Please ask for: Nicola Moore
Email: nicola.moore@arun.gov.uk
Telephone: Ext 37944
Our Ref: FG/109/21/CLP
Your Ref:
Date: 21st June 2021

Lawful Development Certificate for a Proposed Use or Development

Development: Lawful development certificate for the proposed construction of new 4m x 3.6m rear extension with pitched roof.
Location: 21 Highdown Way Ferring BN12 6QQ

Sheet
Proposed Plan & Elevations

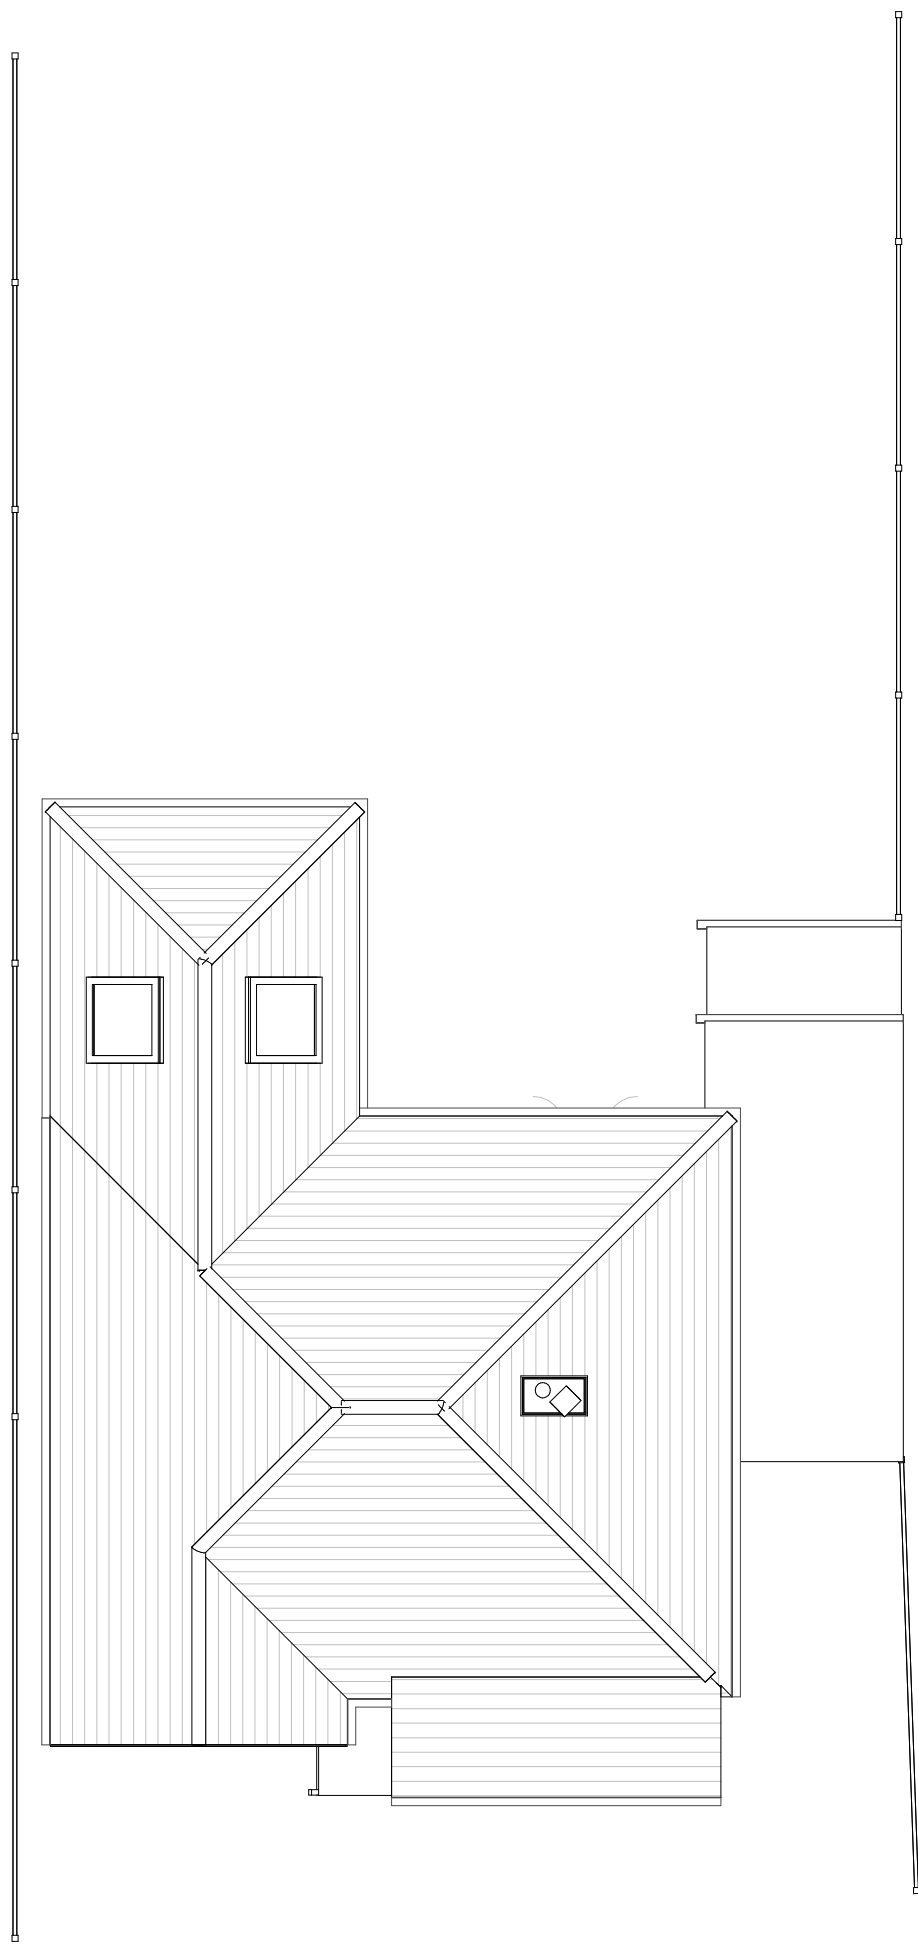
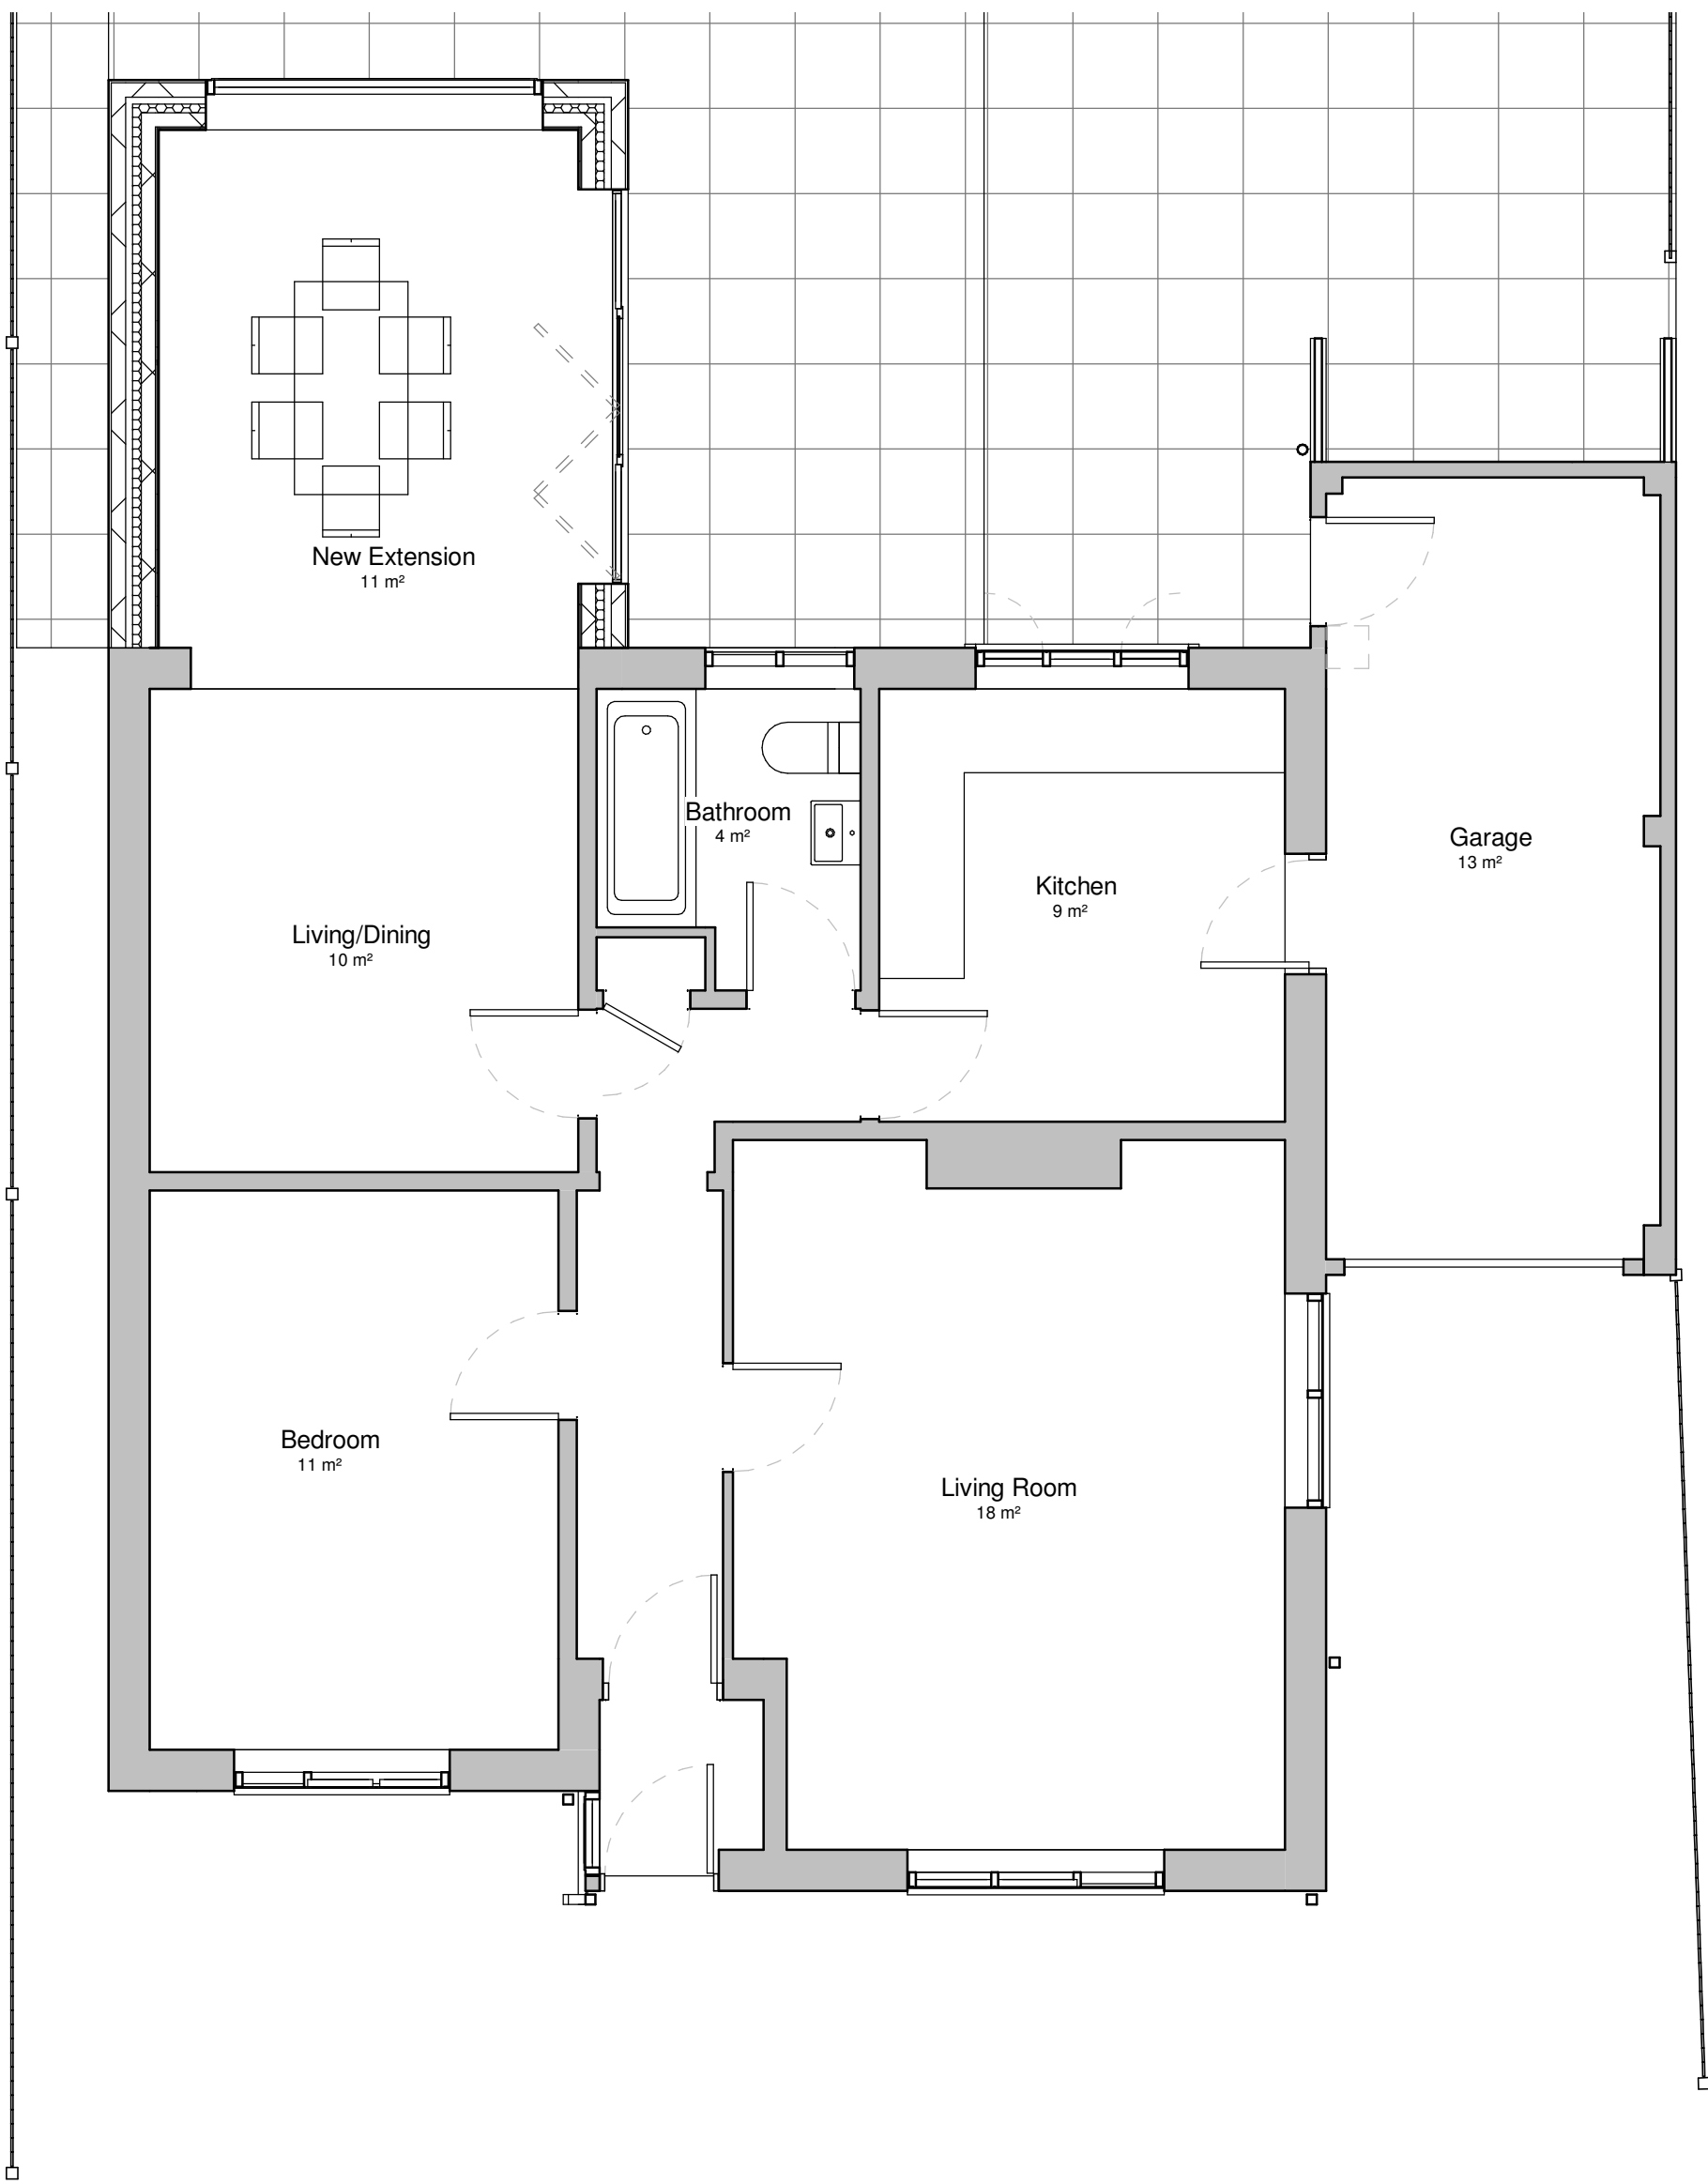
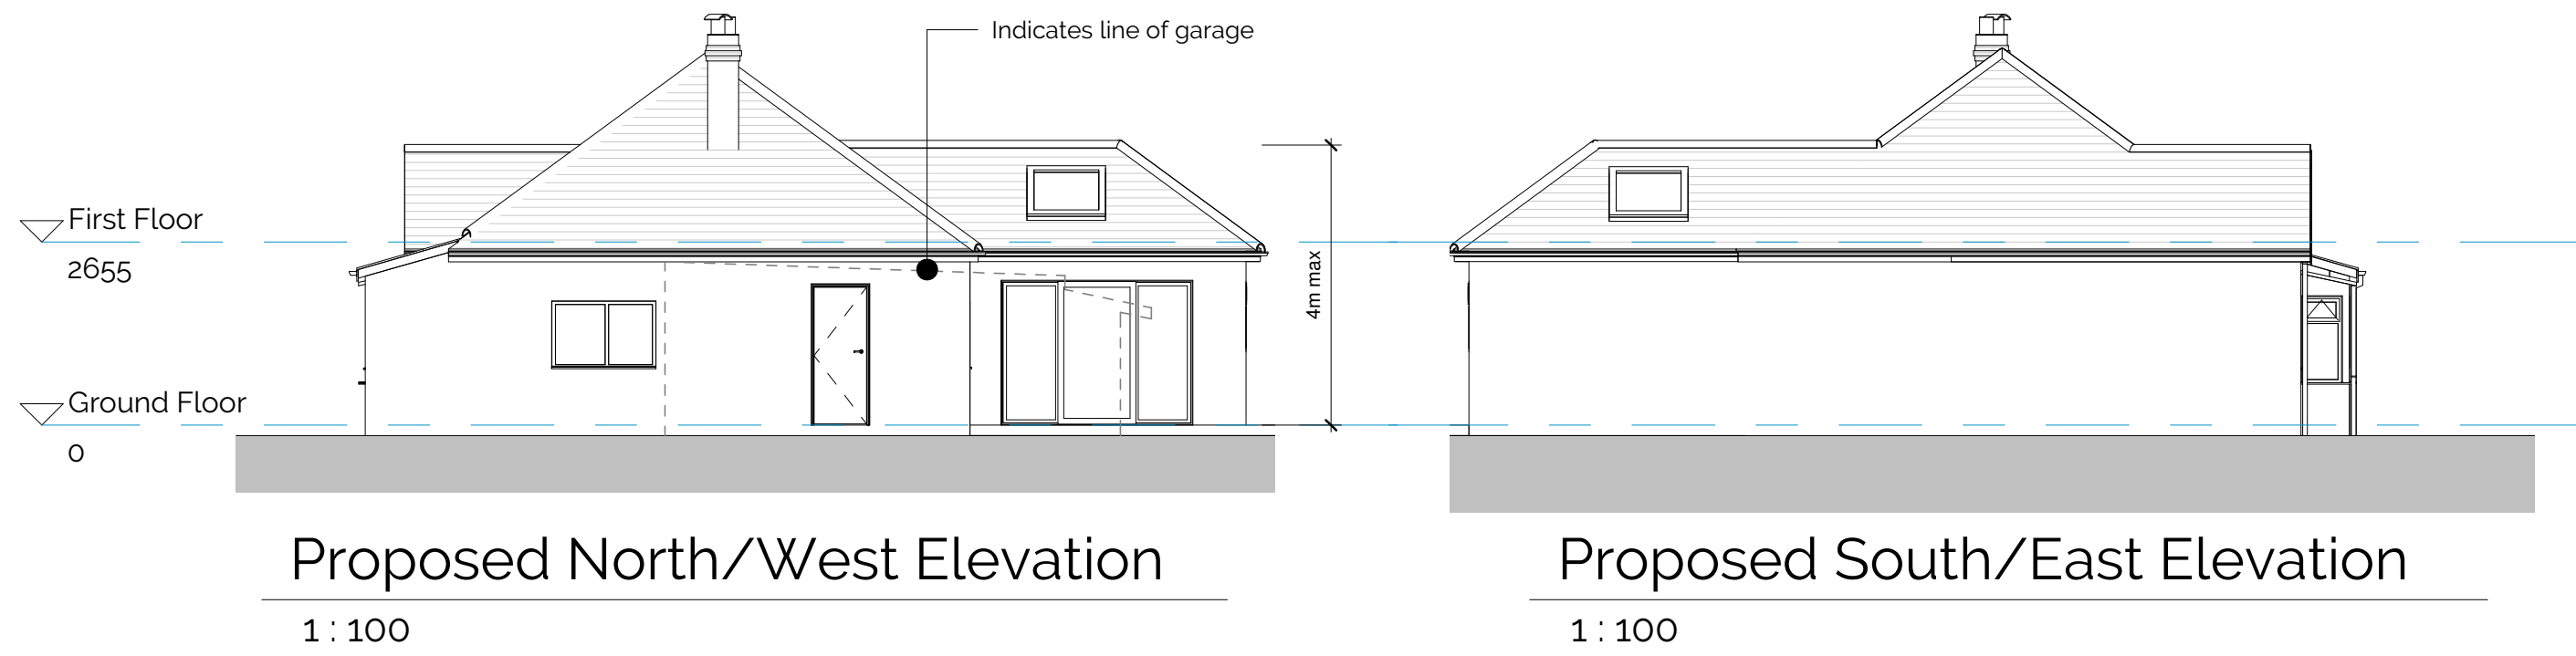
Block Plan

Please amend the Block Plan to include dimensions to boundaries from the proposed extension and re submit.
